Date: 06-Oct-2020
Our Ref: 2020/90441

**Discharge conditions 3, 6, 7, 18 on previous permission 2019/92233 for erection of petrol filling station, including new shop building, canopy, jet-wash and below ground storage tanks
Pennine Service Station, Bradley Road, Bradley, Huddersfield, HD2 1QD
Application Number: 2020/90441**

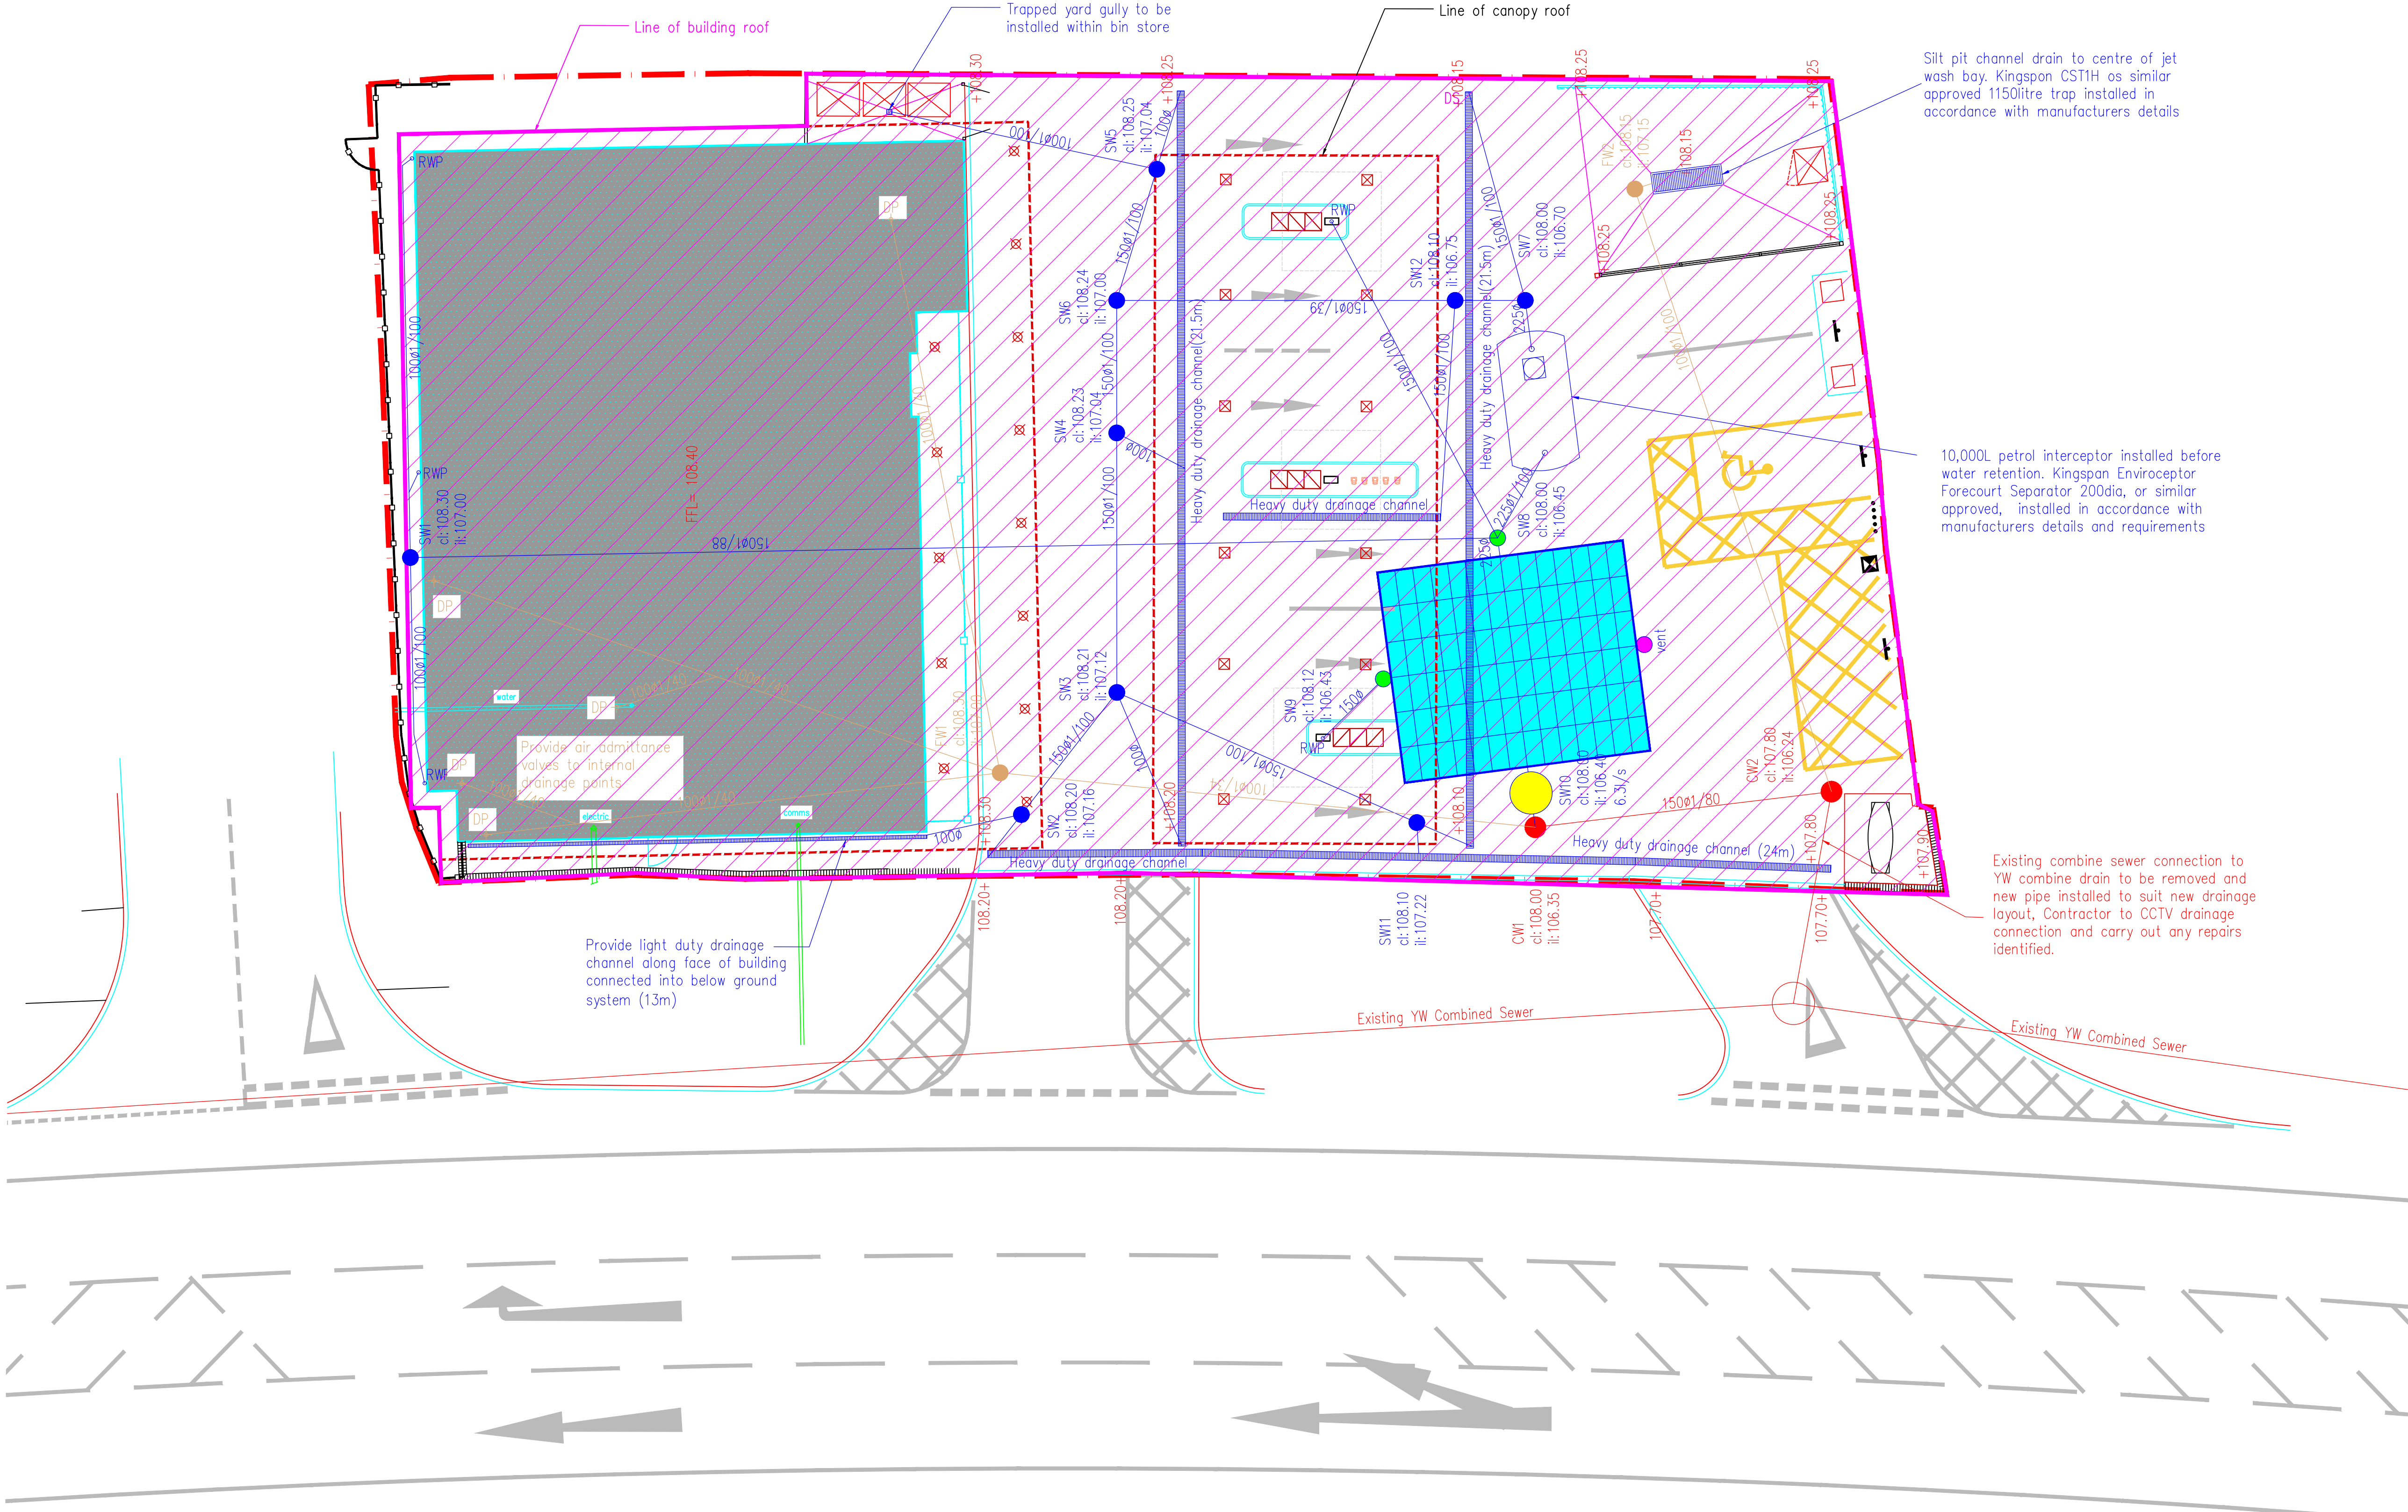
Officers note an inconsistency on the annotations relating to the attenuation tank, showing different sizes. Kirklees Local Planning Authority have no objection to an attenuation tank sized 42m² x 0.8m deep. Any other annotations are not approved.

The cover depth (ground surface to top of pipe/tank) for the attenuation is proposed to be between 0.75m and 0.8m. It is the applicant's (and their engineers') responsibility to ensure the design is safe and suitable for the site use and operation. K.C. Planning and K.C. Lead Local Flood Authority have not instructed any design, but required the applicant to confirm appropriate cover above the attenuation tank to be resistant to vehicle trafficking. The liability for the design lies with the applicant's design engineer and any damage or failure of the system is their responsibility.
